# A47 North Tuddenham to Easton Dualling

## **9.15 Alternative Wood Lane Junction Options Appraisal**

**ALTERNATIVE WOOD LANE JUNCTION OPTIONS APPRAISAL**

<b>Regulation Number:</b>	Rule 8(1)(c)
<b>Planning Inspectorate Scheme Reference</b>	TR010038
<b>Application Document Reference</b>	TR010038/EXAM/9.15
<b>BIM Document Reference</b>	HE551489-GTY-HGN-000-RP-CH-30012
<b>Author:</b>	A47 North Tuddenham to Easton Project Team, Highways England

# PROPOSED WOOD LANE JUNCTION

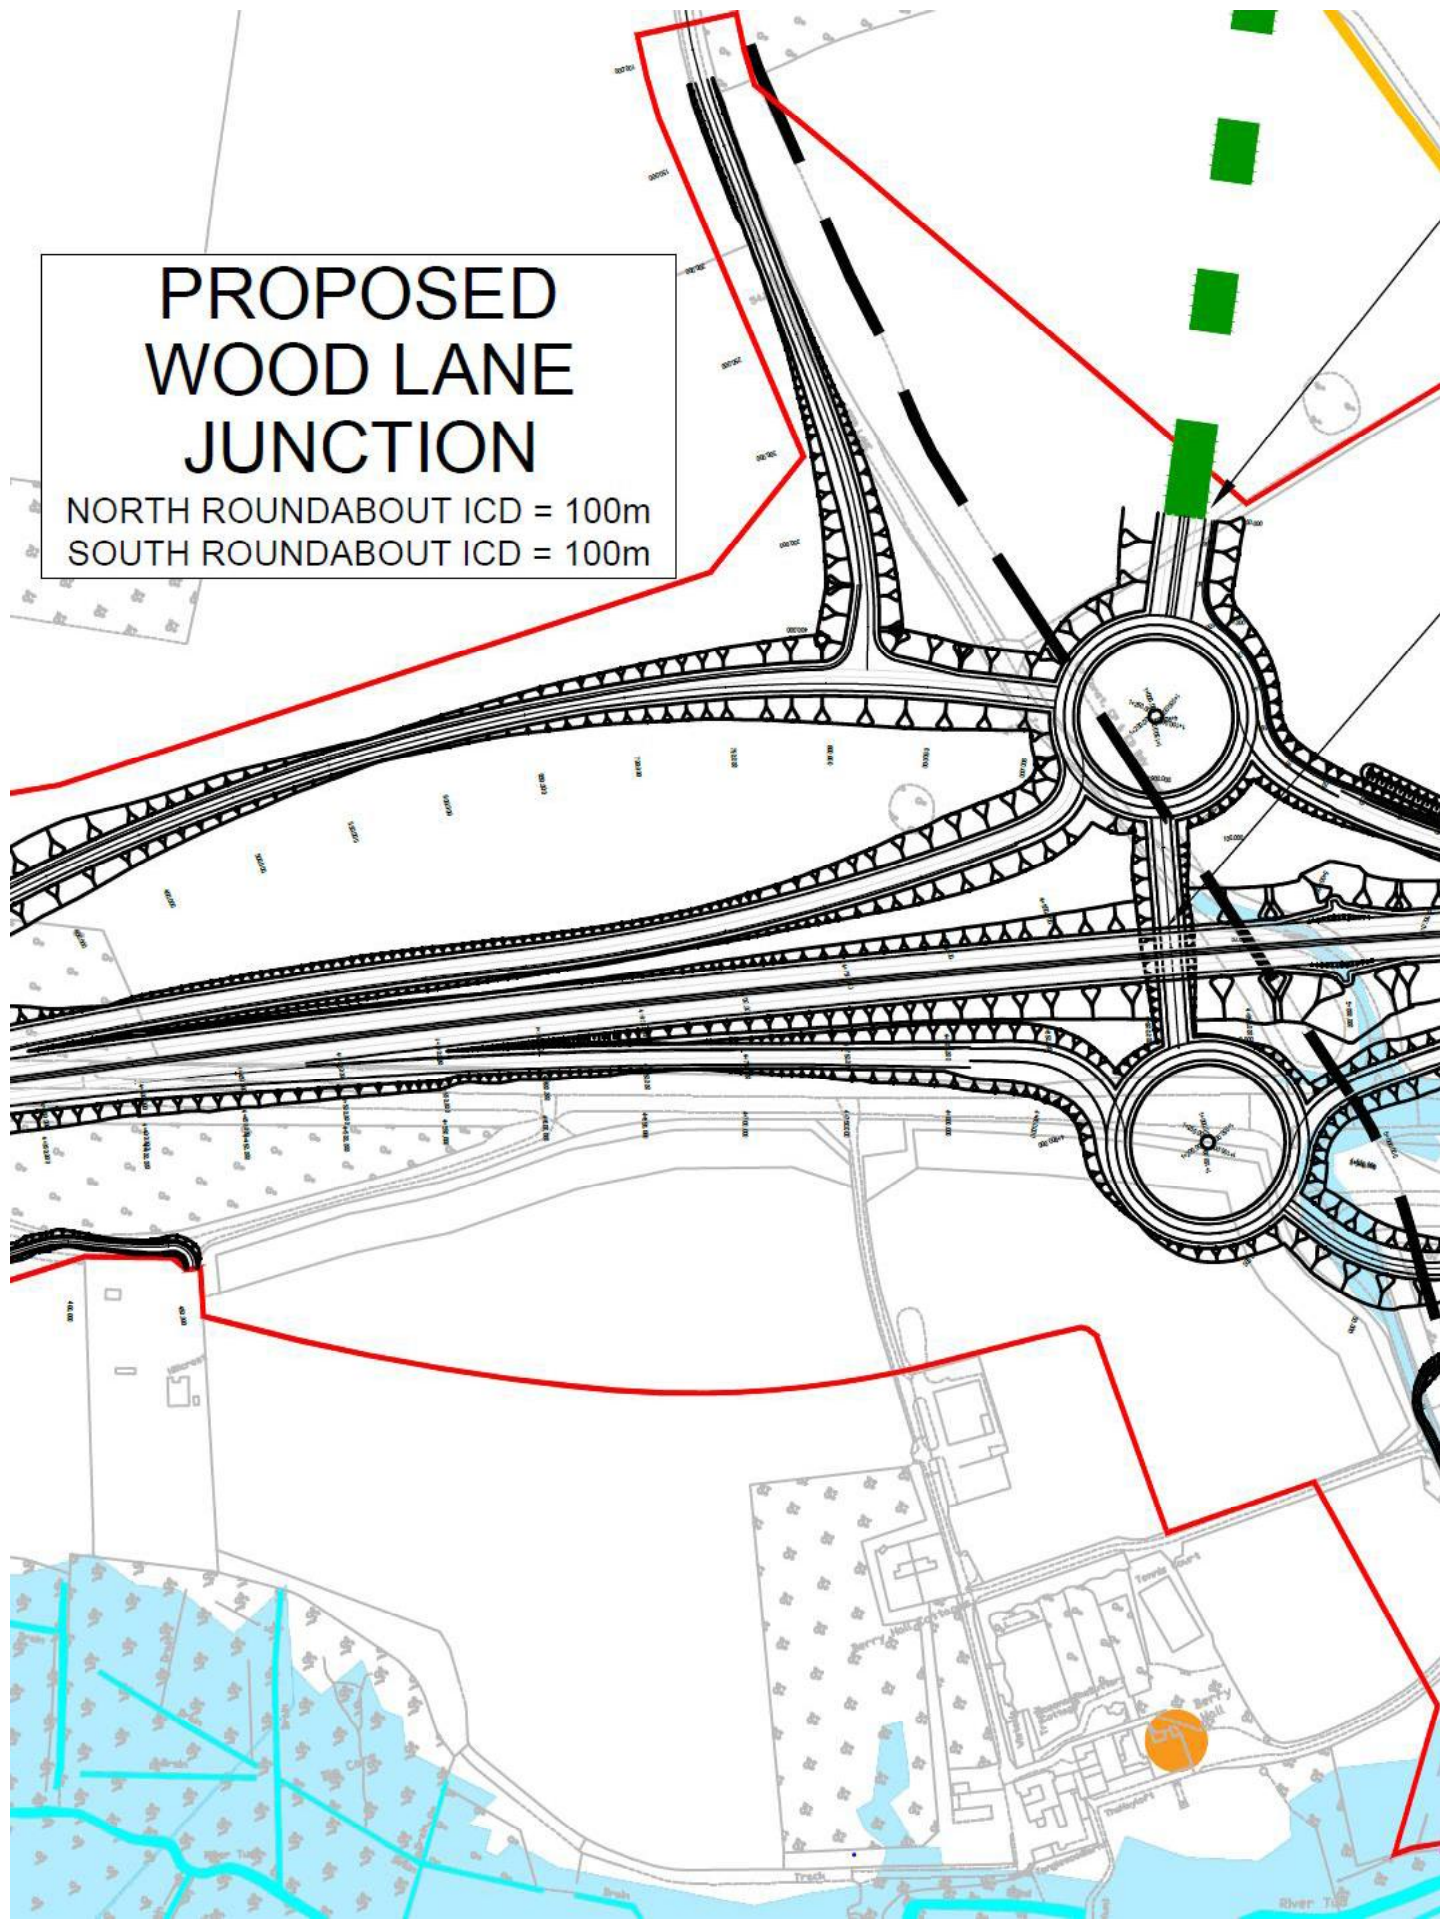
- 3.3.31 No road markings have been provided for the link from the Existing A47 (Detrunken) to the southern roundabout, however from reviewing the widths shown in the drawing this suggests a ghost island junction will be provided.

For an 85kph Design Speed, the 38m spacing of this left/right staggered junction is less than required by CD 123, Clause 2.25 and will require a Departure from Standard.

Additionally, this layout cannot provide the 55m deceleration lengths for either junction, requiring a further Departure from Standard to CD 123, Clause 5.22.

- 3.3.32 The proposed junction of the B1535 Wood Lane with the western A47 link from the northern roundabout is shown as a simple priority junction. This junction is located on a sharp curve (Radius 80m) which is advised against in CD 123, Clause 2.1.1:

Following CD 123 Figure 2.3.1 this “should”<sup>4</sup> be a ghost island junction, this is likely to cause conflicts between the traffic exiting the roundabout and that queuing to turn right into Wood Lane.

This combination of relaxations given the location and proximity of the junctions leads to safety concerns which would require the approval of the Local Highway Authority.
